Ribble Valley Borough Council
Planning Section
Council Offices
Church Walk
Clitheroe
BB7 2RA

Planning Application No: 3/2026/0679

Proposal: Demolition of existing 2 garages and construction of single storey side extension and detached garage. To include relocation of inspection chamber, proposed decking to rear, new ramp access, changes to land levels, new retaining wall and window alterations.

Location: 1 Barker Lane, Mellor, Blackburn BB2 7ED

Figure 1

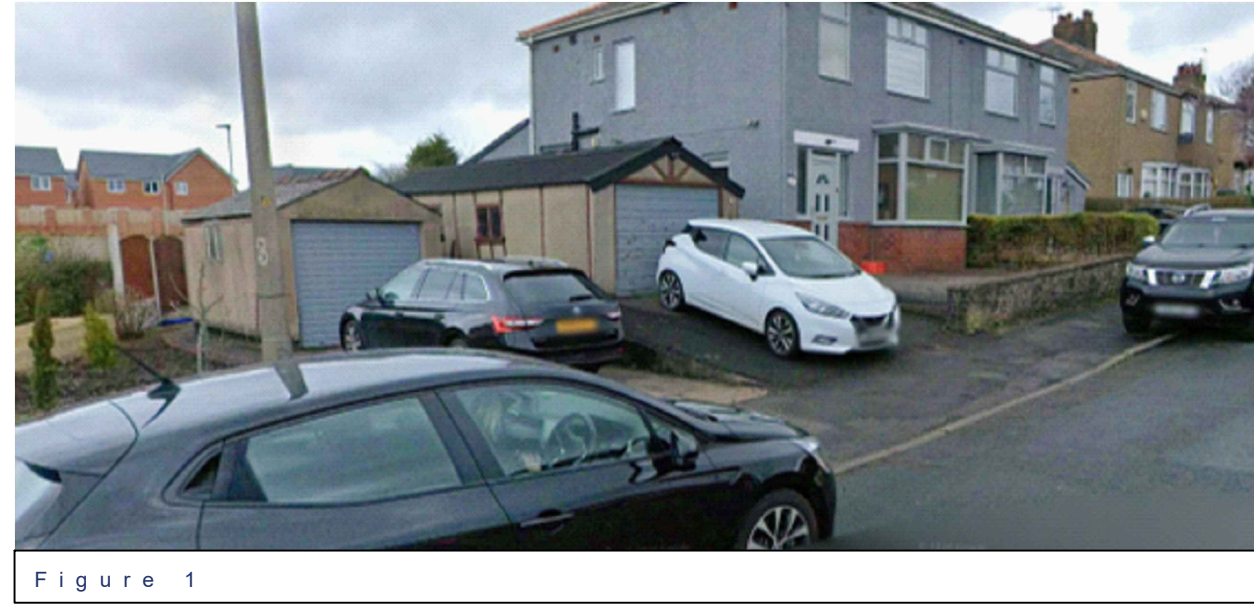
No changes are proposed to the overall off-road parking provision, with the proposed single garage considered adequately sized internally to provide one car parking space and secure cycle storage.

Proposed Site Plan
Scale (1:500)

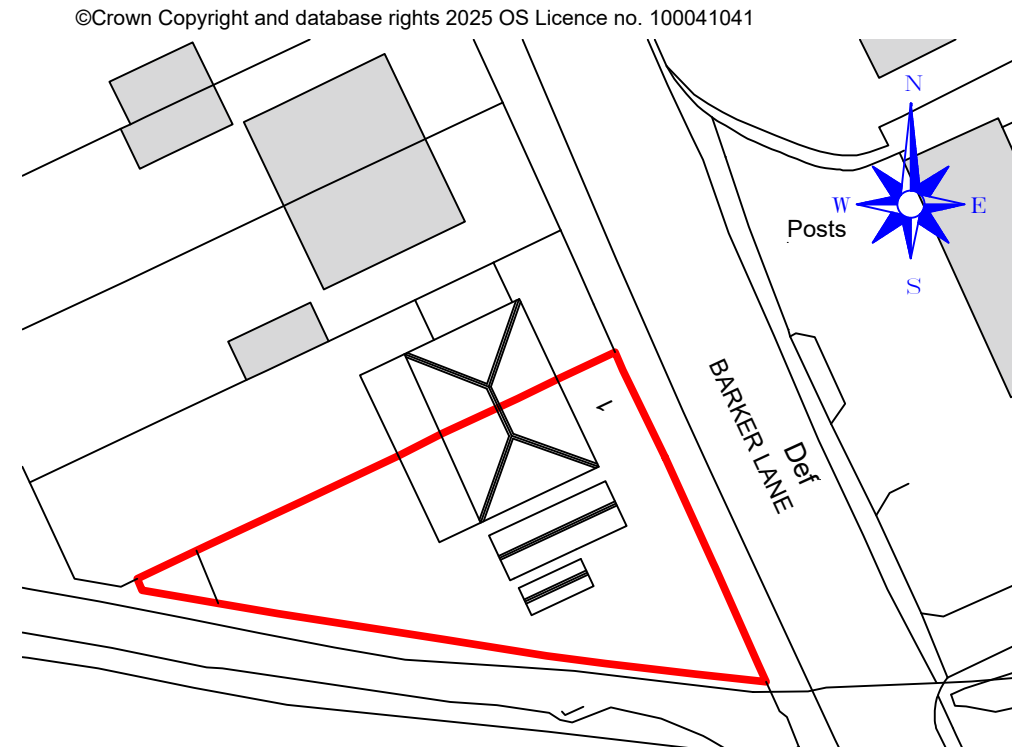
No changes are proposed to the existing vehicular access in terms of width or layout. However, as there will be internal alterations, including renewal of surfacing materials, appropriate measures should be taken to construct a flush kerbed edge tied into the back of the adopted footway on Barker Lane to protect the structural integrity of the adopted highway network.

Prior to the commencement of any development the applicant should provide kerbing and tie in details along the rear edge of the footway maintained at public expense on Barker Lane to ensure that any works carried out are not to the detriment of the highway network maintained at public expense. The necessary details can be obtained from the highways authority by e-mailing developeras@lancashire.gov.uk , quoting the planning application number.
